WEST SUSSEX COUNTY COUNCIL CONSULTATION

TO:	Arun District Council FAO: Michael Eastham
FROM:	WSCC - Highway Authority
DATE:	20 October 2021
LOCATION:	Land to the south of Ford Lane and East of North End Road Yapton BN18 0DS
SUBJECT:	Y/123/21/PL Variation of condition imposed under Y/82/20/RES relating to condition 1 - plans condition.
DATE OF SITE VISIT:	n/a (Desktop study)
RECOMMENDATION:	Modification
S106 CONTRIBUTION TOTAL:	n/a for purposes of this specific planning application

Location Plan - PRoW no.357

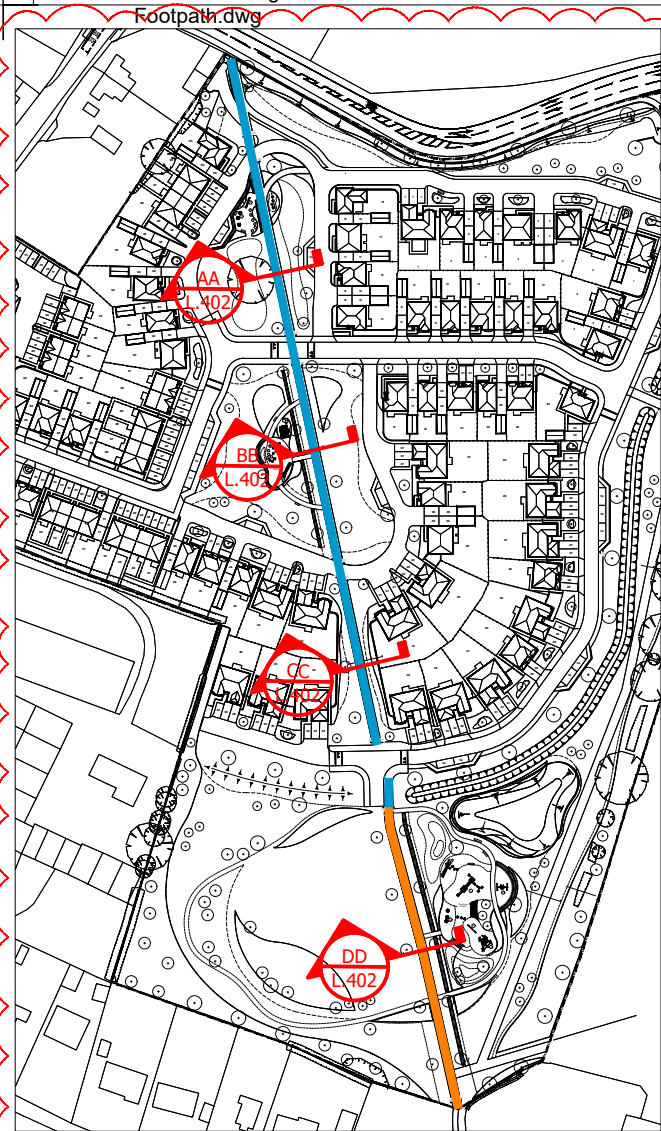
Following review of the submitted drawings, one area of concern presents itself. This is the revised position of the turning head found on the southern-most access road. Where it is shown bisects the line of Public Footpath No. 357. While the legal line of the PRow does not appear altered it does make any future upgrading to either a cycle route or bridleway potentially difficult given the alignment and purpose of the turning head to turn vehicles. This is because any future upgrading is likely to require physical alterations to the road surface in an attempt to give non-motorised users priority in accordance with latest design guidance and having the turning head in the position as currently proposed will make this difficult to achieve. As such, the turning head should be moved off the legal line of the PRow.
